From: Bruce Taunton
Sent: 29 October 2014 13:53
To: Planning.Responses
Subject: RE: Planning Consultation on: FG/136/14/PL

NOTIFICATION FROM ARUN DISTRICT COUNCIL
Town & Country Planning Act 1990 (as amended)
Town and Country Planning (Development Management Procedure)
(England) Order 2010 (as amended)
Planning Permission
APPLICATION **FG/136/14/PL**
NO:

Registered: 13th October
 2014
Site Address: Ferring Country Centre Rife Way Ferring BN12
 5JZ

Description of Works: Amendments to ground floor layout including replacement WC's and new staircase to 1st floor (20sq.m), new layout and staircase to existing 1st floor store, layout to include; offices, meeting room, WC and staffroom (215sq.m), new 60no space car park adjacent to Country Centre (2950sq.m), new bitumen surface construction to section of existing pedestrian path (176.5sq.m).

DRAWING TITLE:
PLANNING
Proposed Site Plan (Inc.
Car Park and New Path).

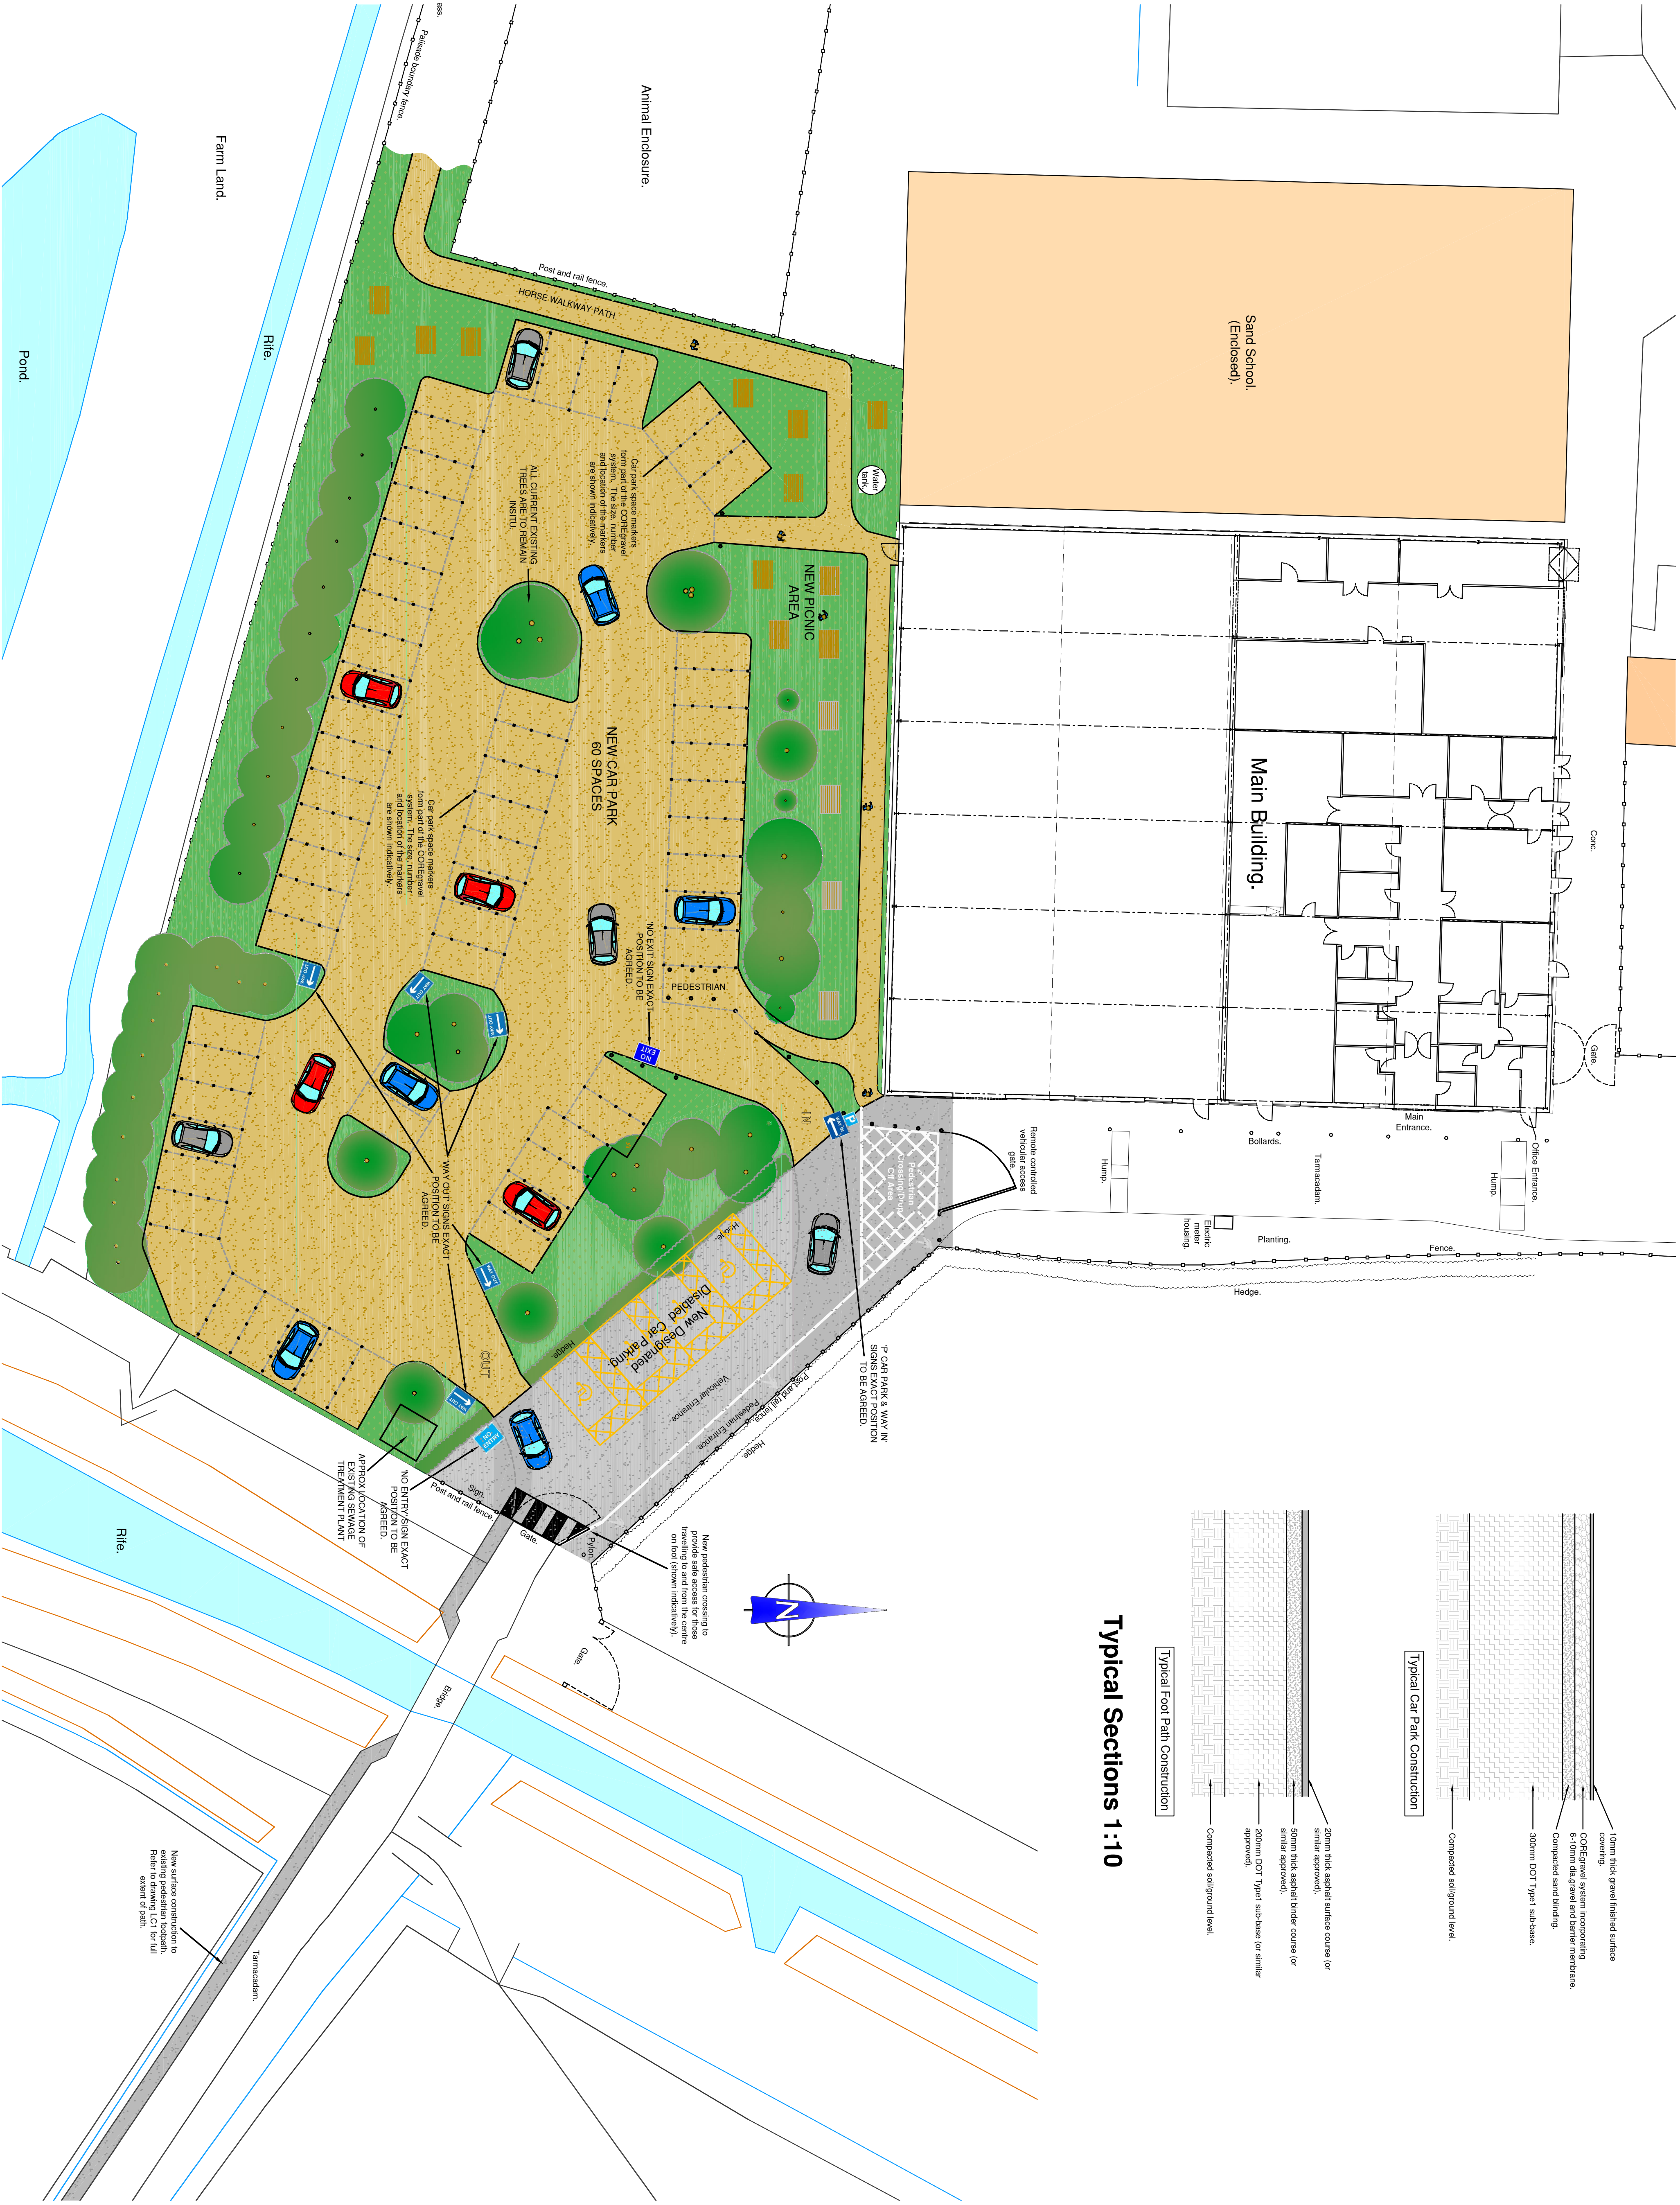
The main alterations within the building will need to satisfy the Building Regulations. The choice of material will not change the external landscaping (parking) areas existing surface water run-off rates and is considered satisfactory.
